**Our Ref: AW/354/18/HH**

**Town & Country Planning Act 1990 (as amended)  
Town & country Planning (Development Management Procedure) (England) Order 2015  
Application for Householder Planning Permission**

**Development** New vehicular access & permeable composit material to front garden for parking.  
**Location** Queensbury 4 Aldwick Street Aldwick

PROPOSED VEHICULAR ACCESS AT 4,ALDWICK STREET, ALDWICK FOR MR.& MRS.N.PROSSER

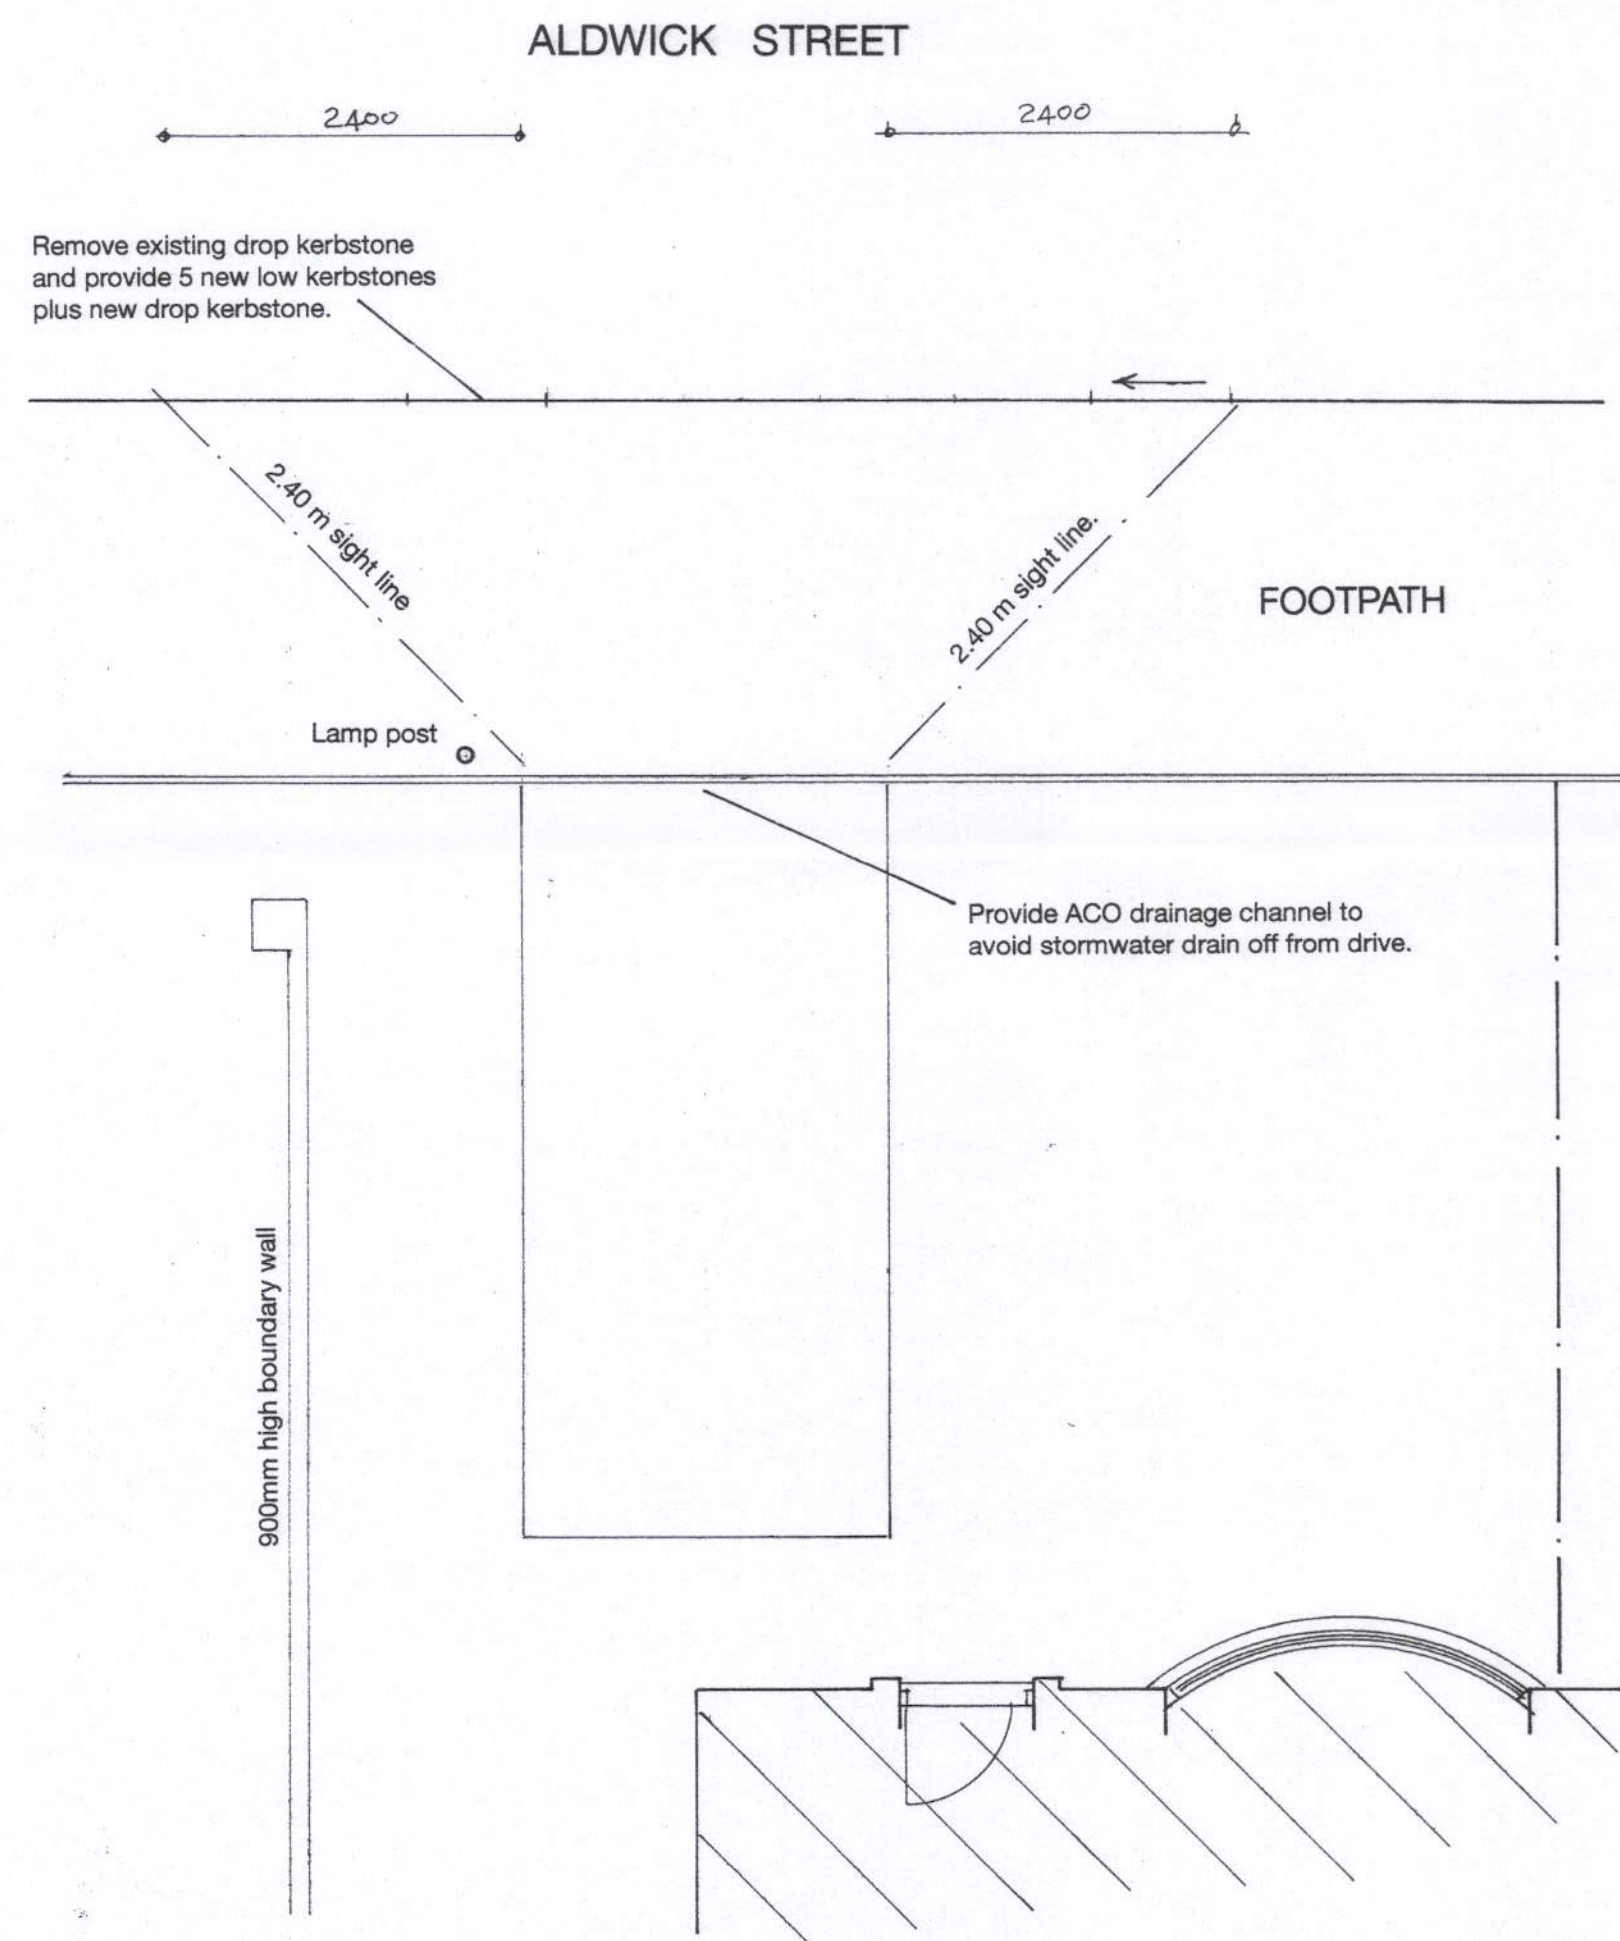
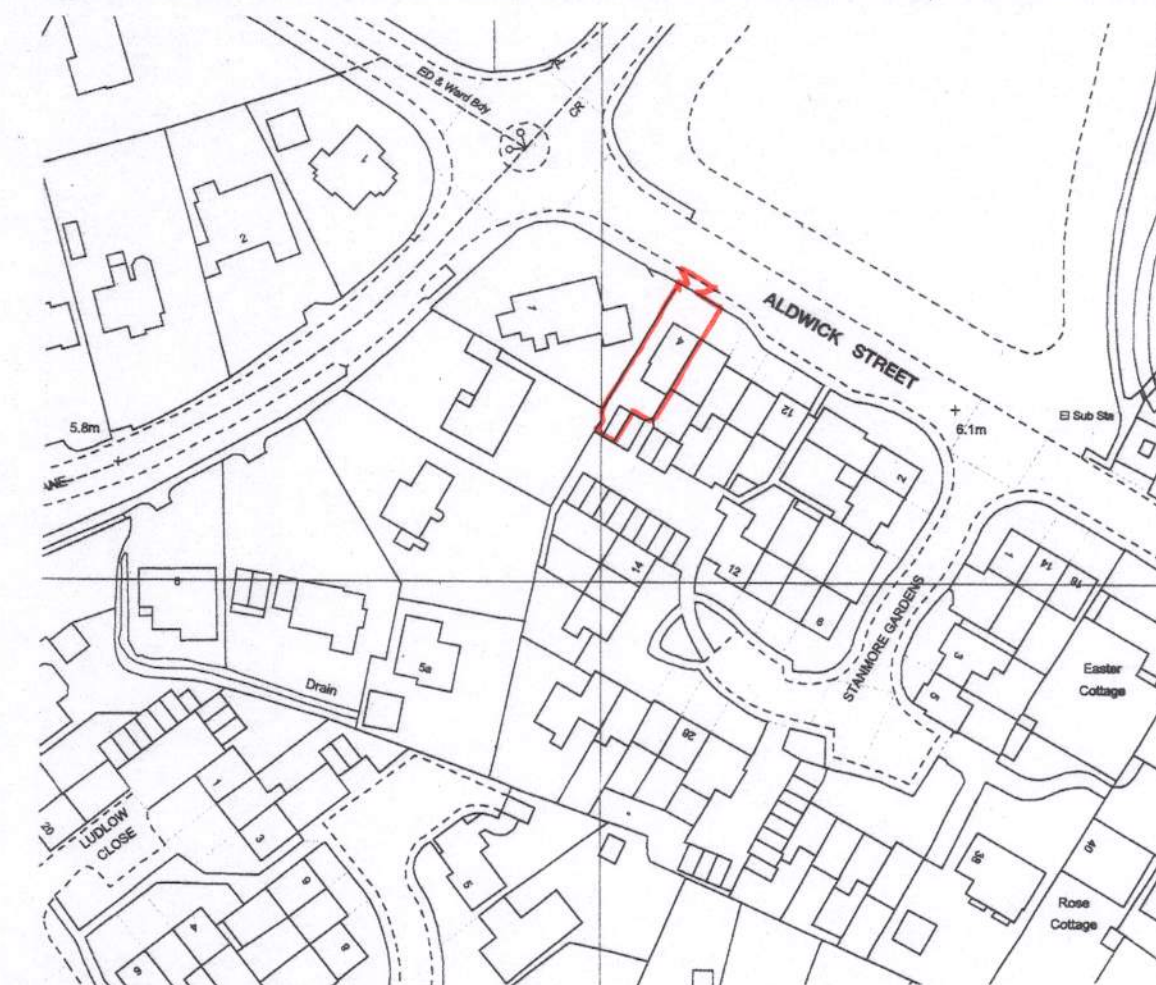
Please provide visibility splays on the block plan. A visibility splay is formed by measuring to a point 2.4m back from the carriageway in the centre of the driveway or entrance. A line (70m long in the case of a 30mph limit) is then drawn to the right, to a point where it strikes the near-side edge of the carriageway.
